# Rosefield Solar Farm (EN010158)

**Rosefield Solar Farm – Buckinghamshire Council's  
comments on Applicant's Updated Deadline 2 Documents**

Buckinghamshire Council

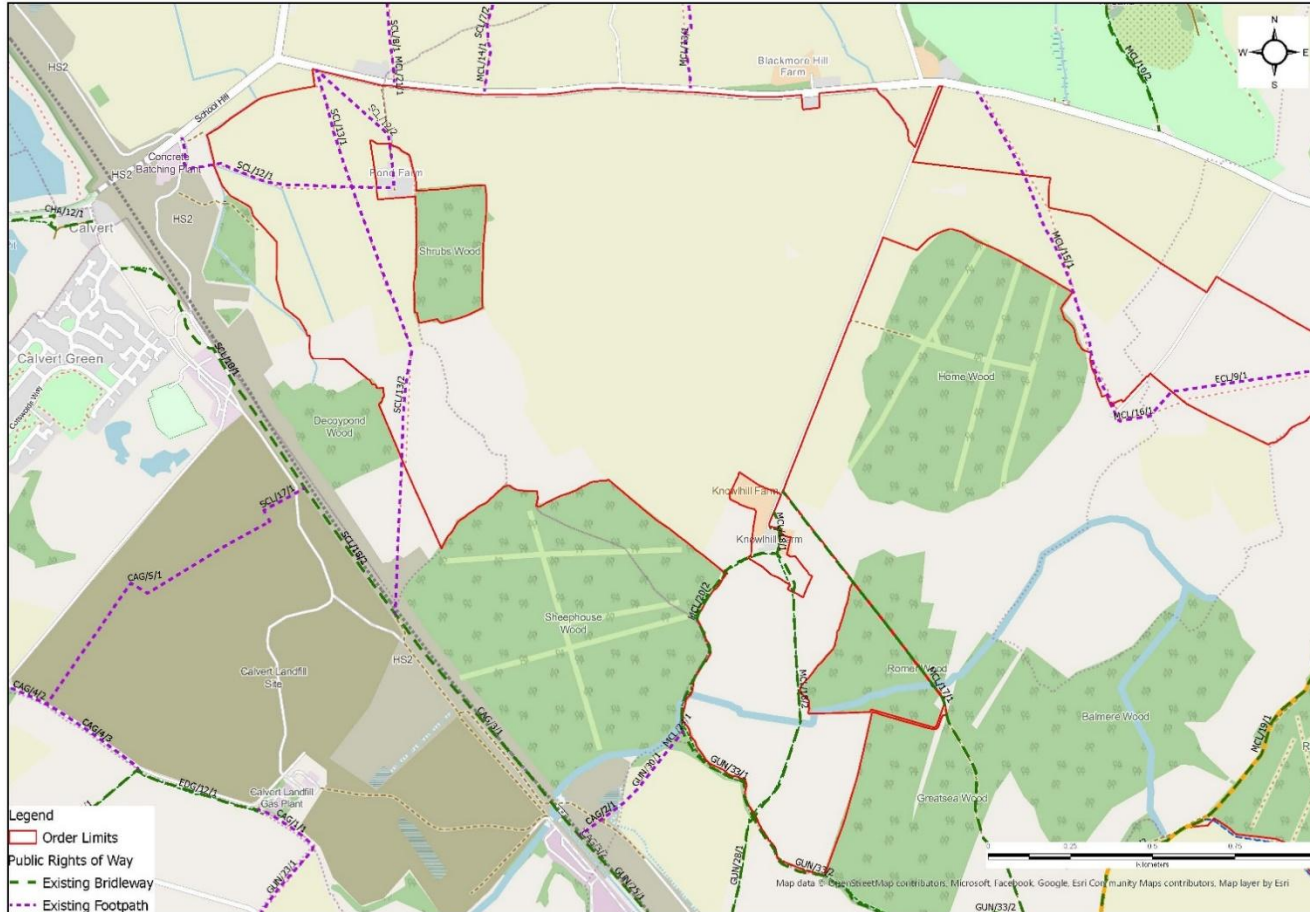
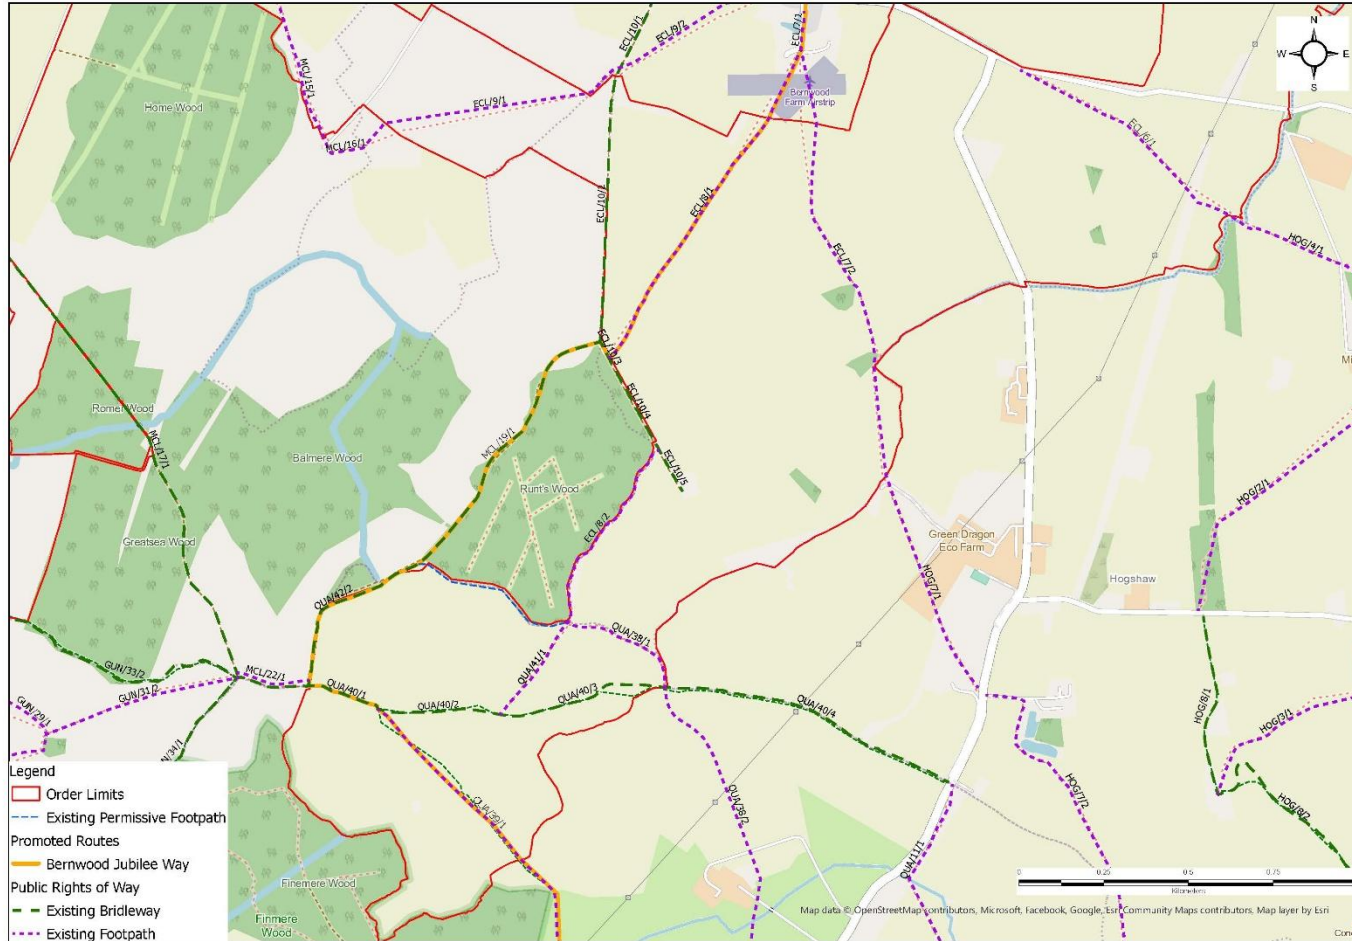
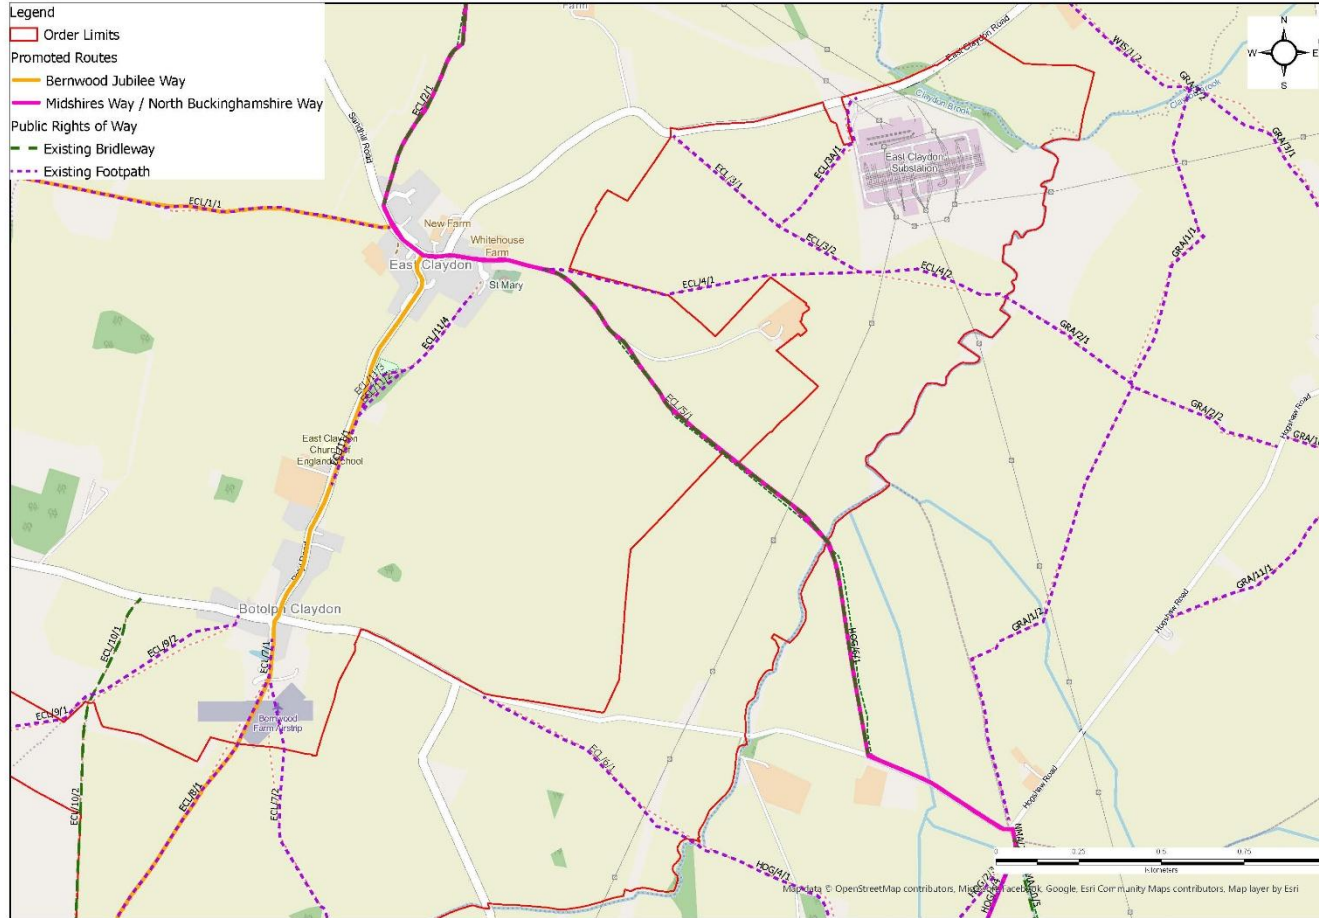
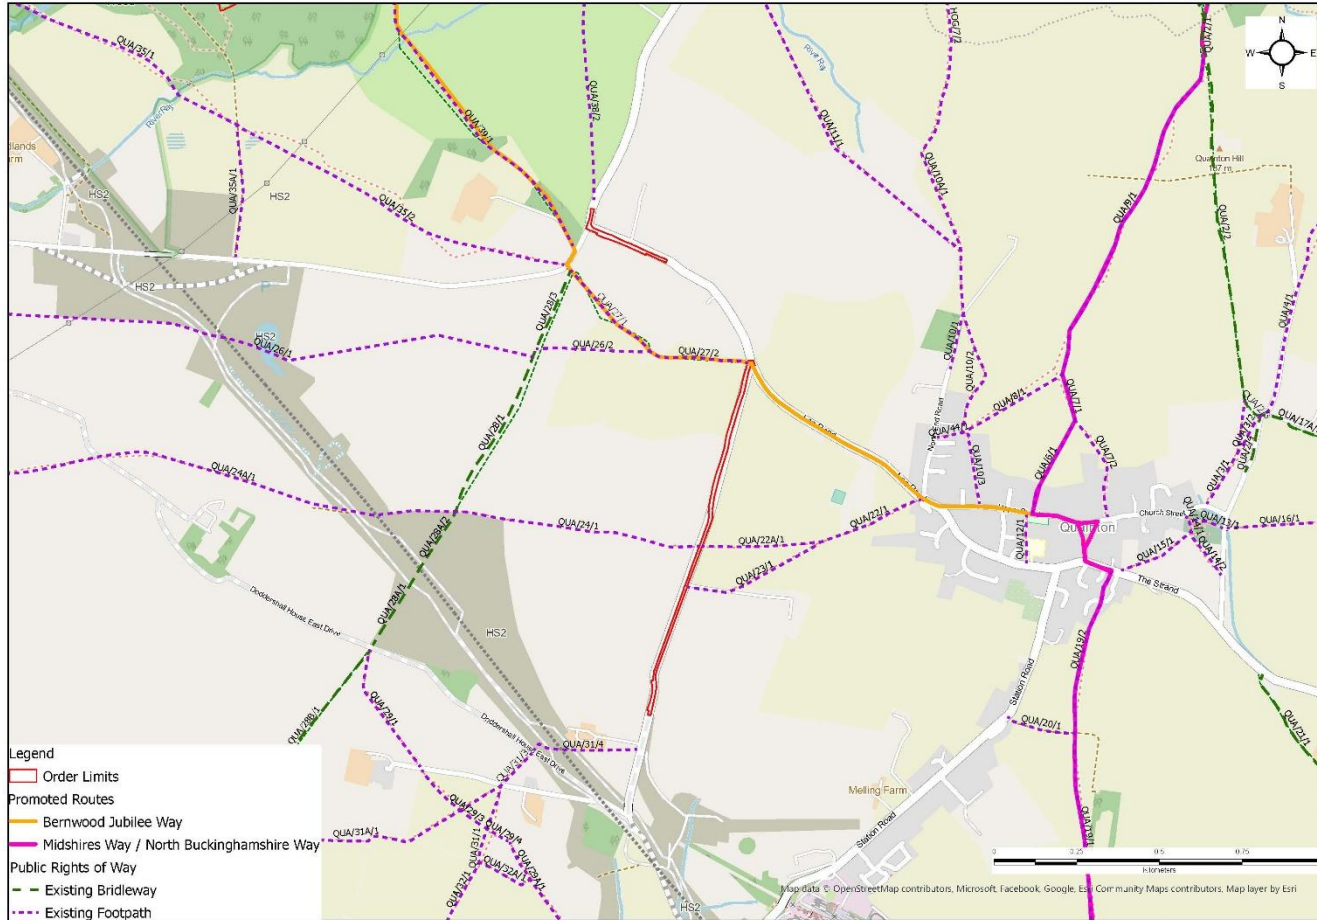
Doc ref	Doc Title	Buckinghamshire Council Comments
		Field capacity days can indicate the proportion of the year that the soils are at field capacity and susceptible to damage but not their resilience to damage when they are in a dry, friable state that is suitable for handling.
Doc ref	Doc Title	Buckinghamshire Council Comments
<a href="#">REP2-072</a>	7.8.3 Outline Rights of Way and Access Strategy (RoWAS) (Tracked) (Rev 3)	<p>The RoWAS has been updated to include: 1) recorded minimum widths of 2m for diverted rights of way; and 2) a survey assessing opportunities to replace stiles for gates to improve access for all abilities. These updates are welcome and resolve the matters. Regarding the latter, at para 4.3.3, there is no need to be concerned about minimum widths at field/hedge boundaries as BS 5709 2018 only requires space in the hedge for a gate or 1.1m gap (footpath), depending on stock control.</p> <p>The Council has suggested two improved options for the layout of the footpath diversions north-west of Pond Farm, described in para 7.1.2 and between Fields B5 and B13. While the Applicant's proposal benefits east to west movements to avoid 200m of road walking, which is a benefit (pink route), the council's suggested routes (green) follow desire-lines that avoid right angle bends (and possibly being fenced off in future), which is considered more desirable.</p>

Doc ref	Doc Title	Buckinghamshire Council Comments
		 <p data-bbox="1144 662 1892 694">green = created footpath and black = deleted footpath</p> <p data-bbox="1144 1173 1948 1204">Pink = created footpath and black = deleted footpath (ignore green).</p> <p data-bbox="1144 1228 1982 1292">Although both work to different degrees, the green paths more closely reflect the historic passage of walkers.</p>
